From: [REDACTED]
Sent: 01 June 2024 19:50
To: Planning
Cc: [REDACTED]
Subject: Application 3/2024/0327

Planning Application Reference No.: 3/2024/0327

Address of Development: Pendle Mill Pendle Road Clitheroe

Drawing file: planx_downloads / 24_0327_Proposed_Site_Plan_Rev_L.pdf

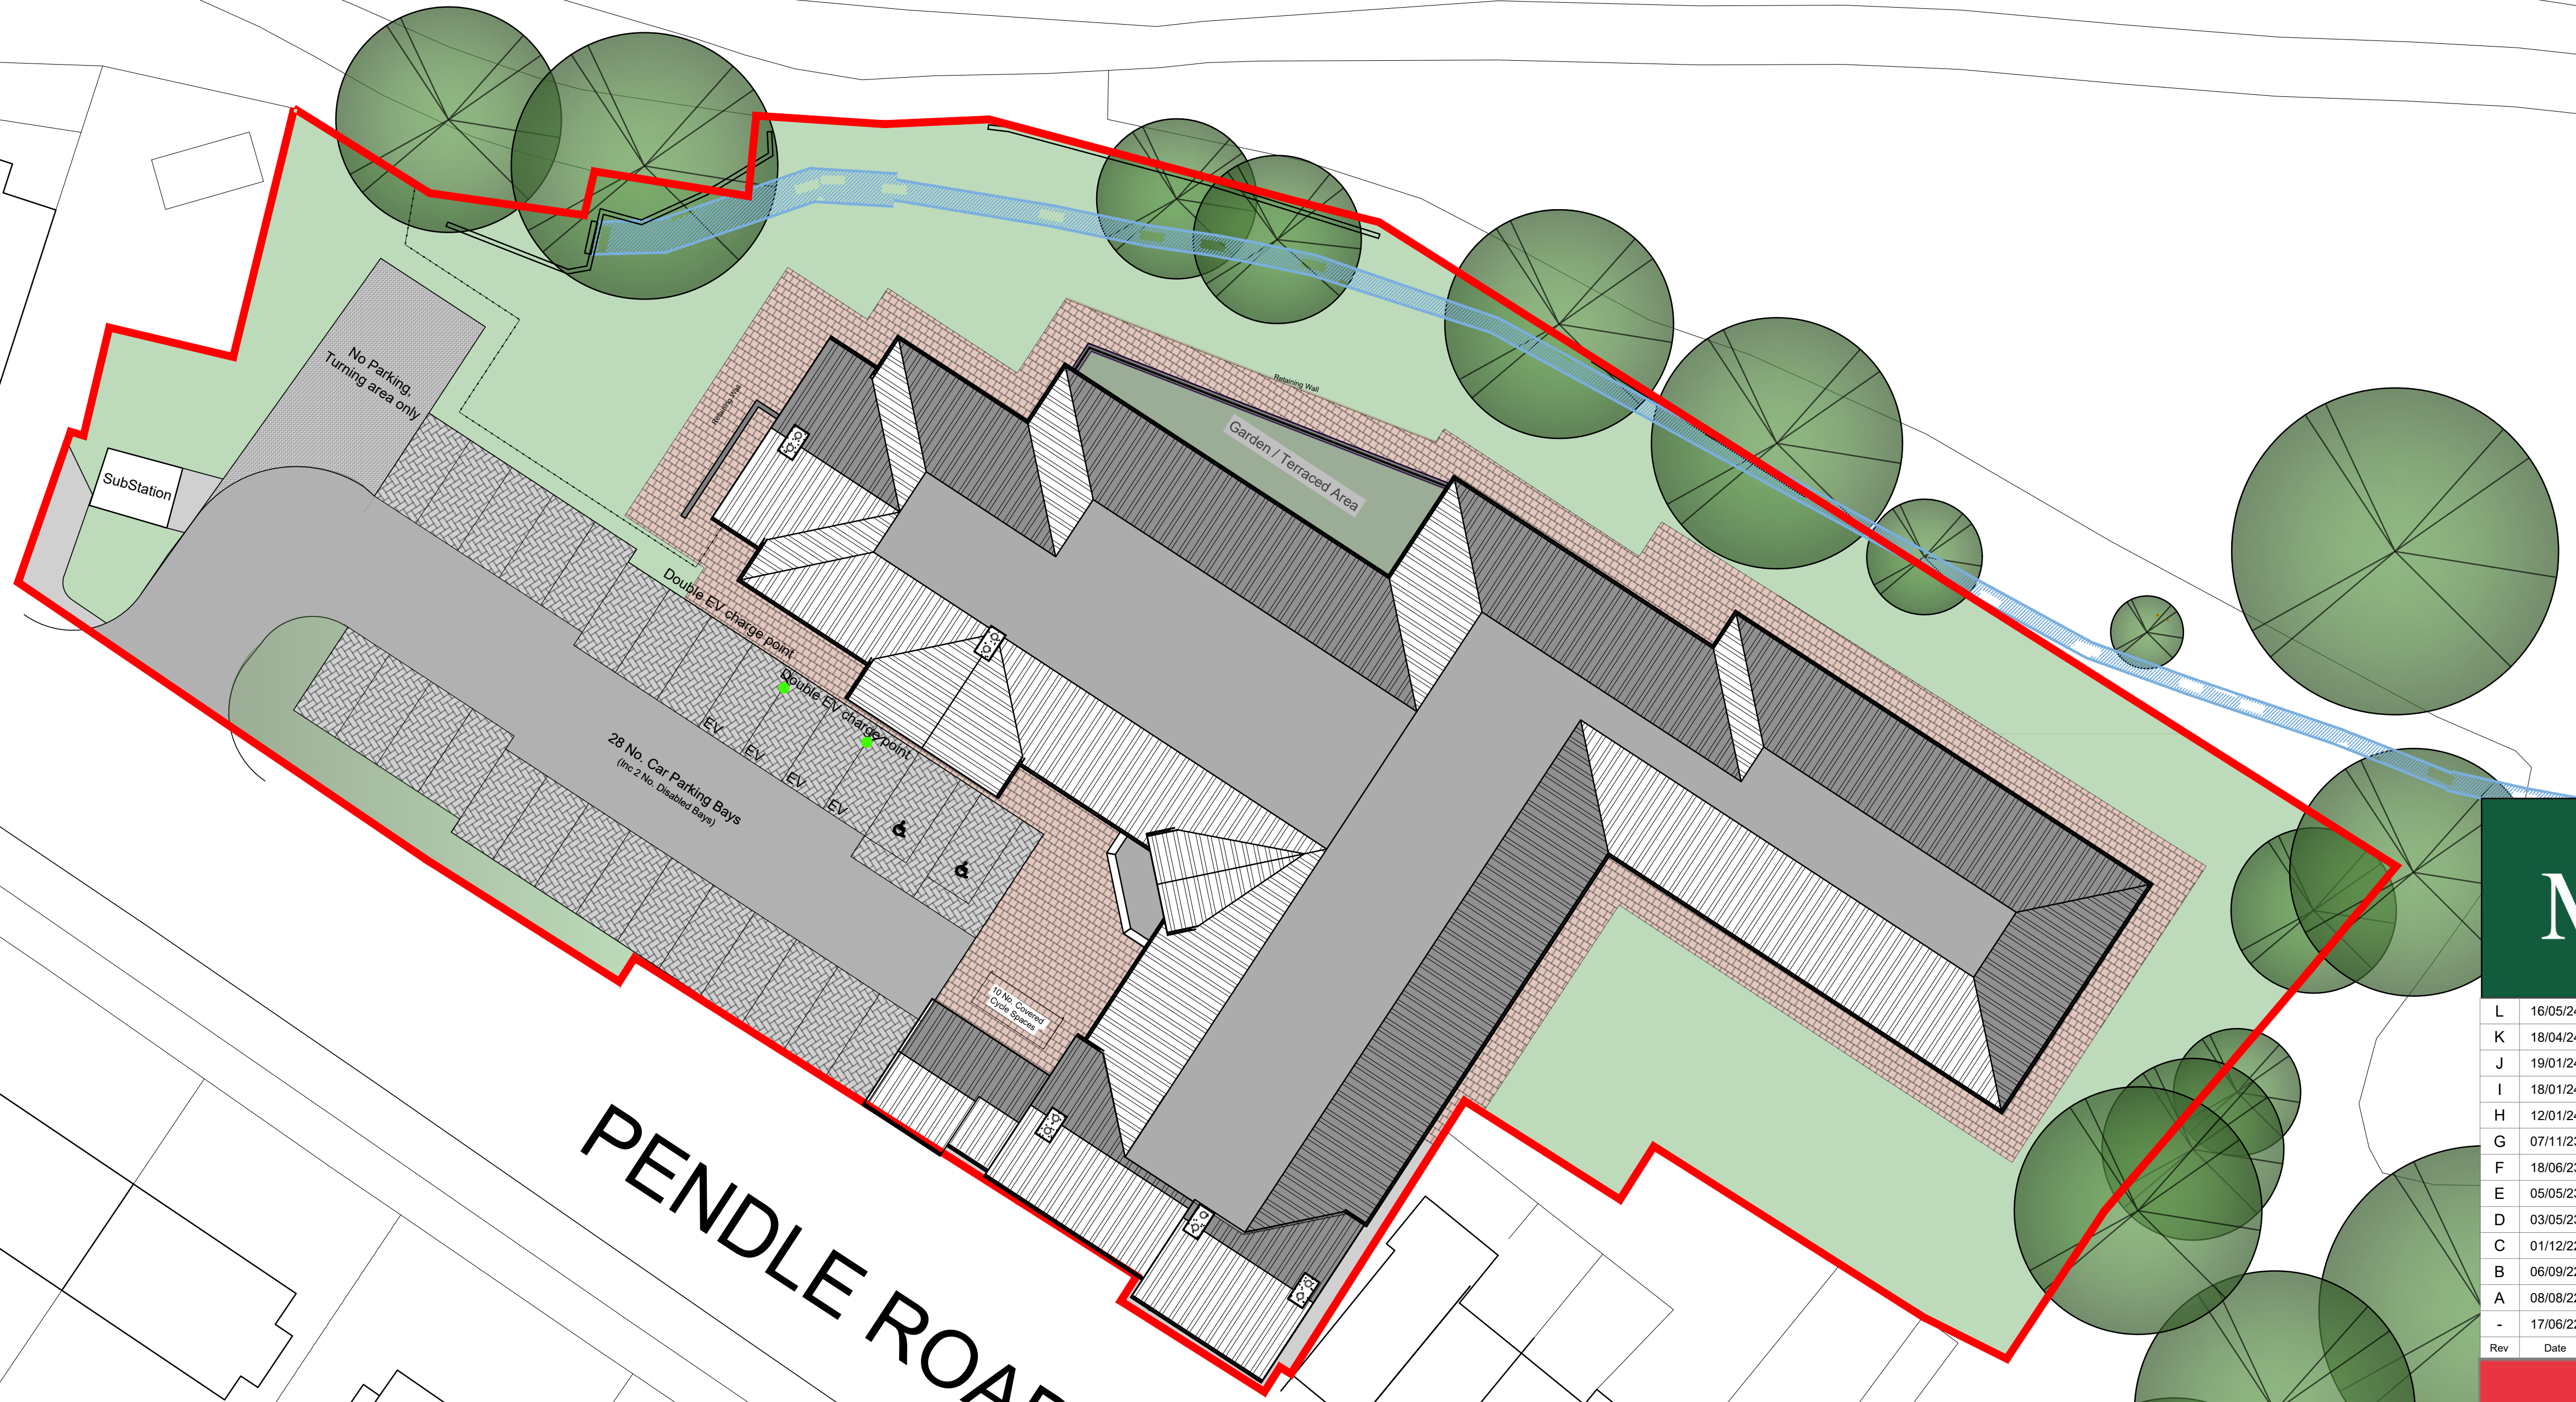
Comments: The Top Water drains from [REDACTED] and the Road water drains past down the Occupation Road to [REDACTED]. on the Plan they are taking down the wall building across the road to enlarge the site, What happen to [REDACTED] top Water and to the road drainage, it is not shown on the plan
